SUBJECT: Engineering Review Comment
Mountain View Electric Association Inc. (MVEA)

Project Name: Hill Minor Subdivision – Lot 1, C and H Estates

Project Number: VR2313

HILL SUBDIVISION FILING NO. 1

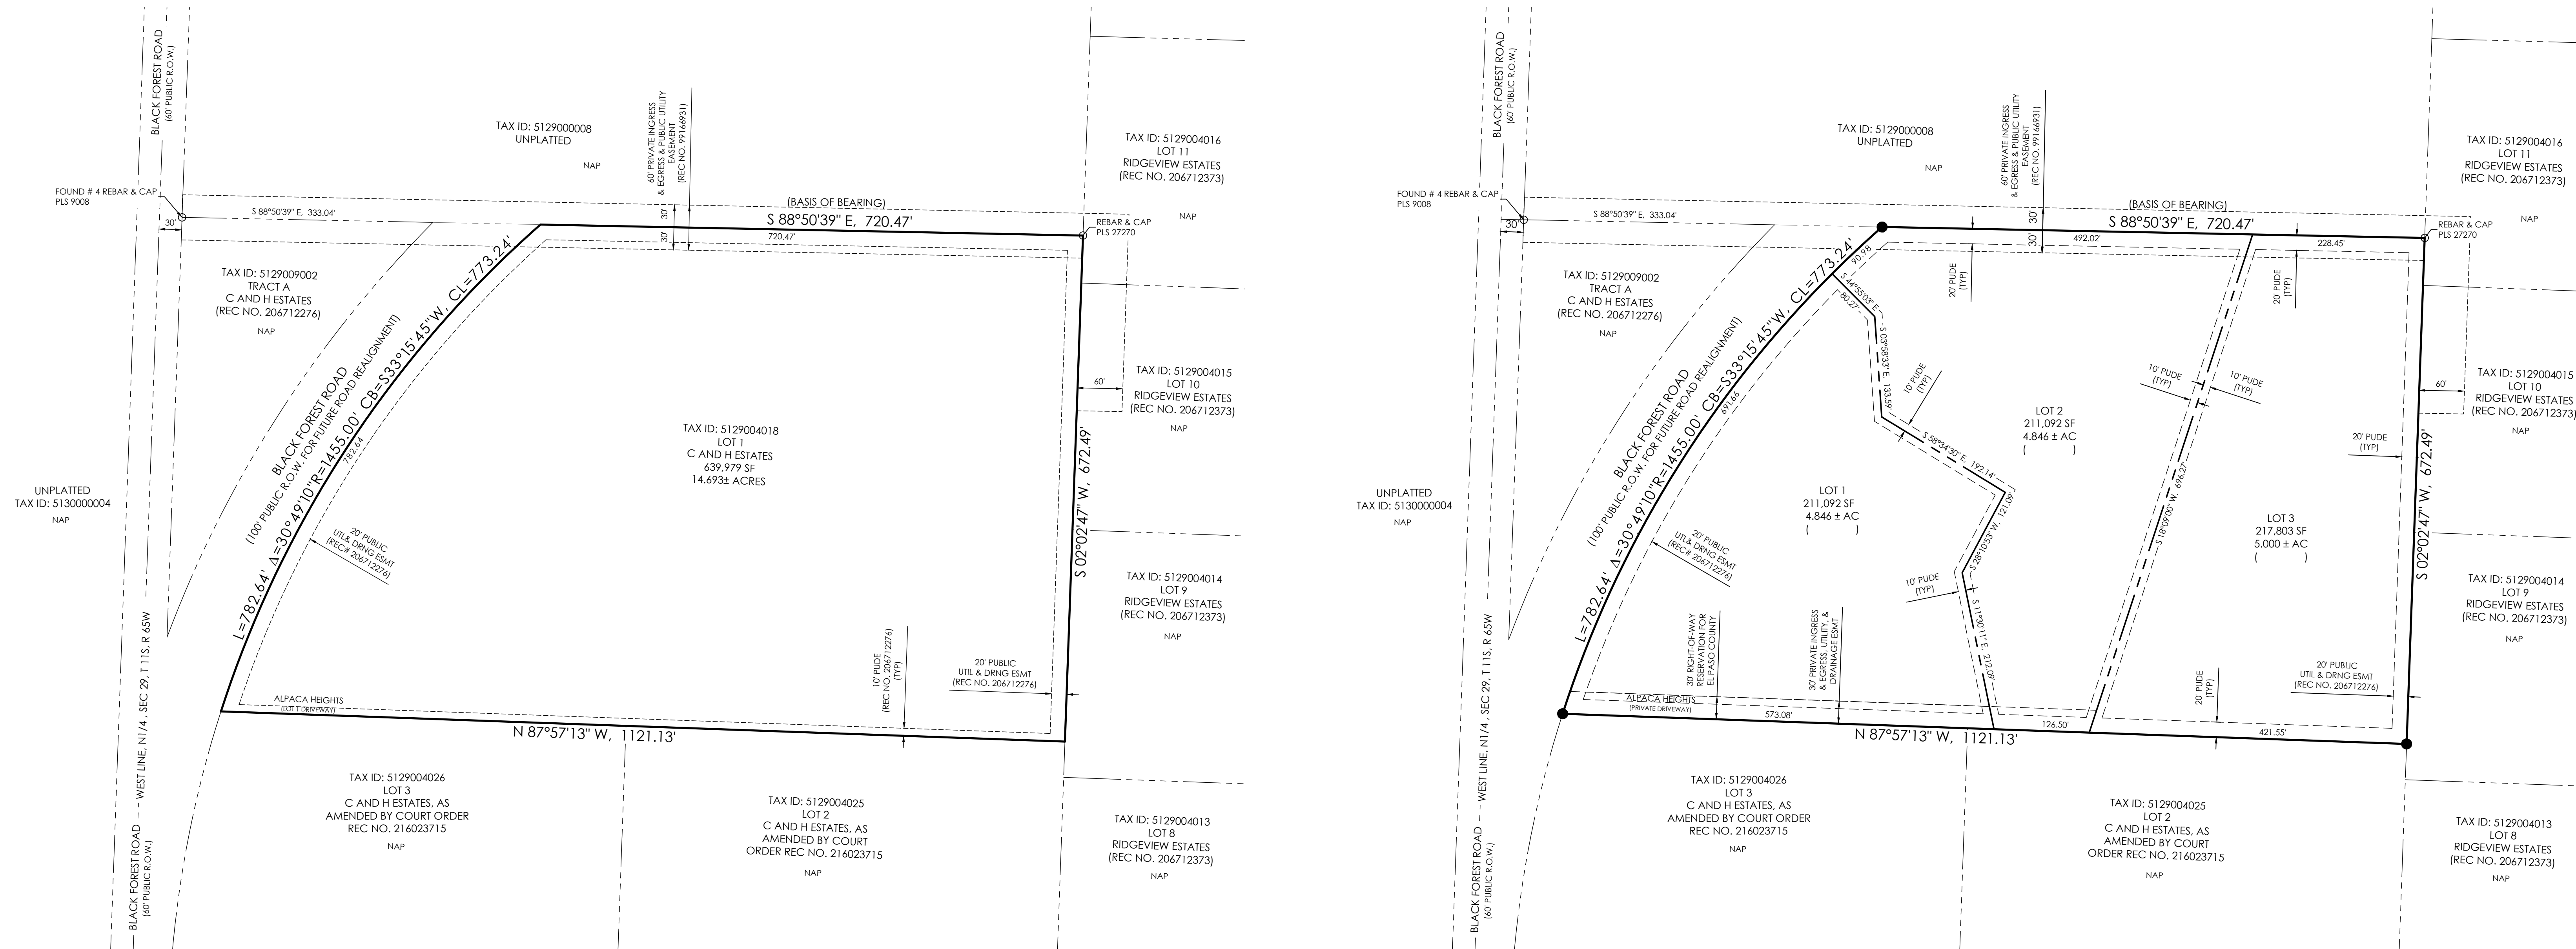
MVEA requests a ten (10) foot front, side, and rear lot utility easements adjacent to the Alpaca Heights ingress/egress public utility easement. MVEA also requests the platting of MVEA's existing facilities with easements on the plat. Additional easements may be required.
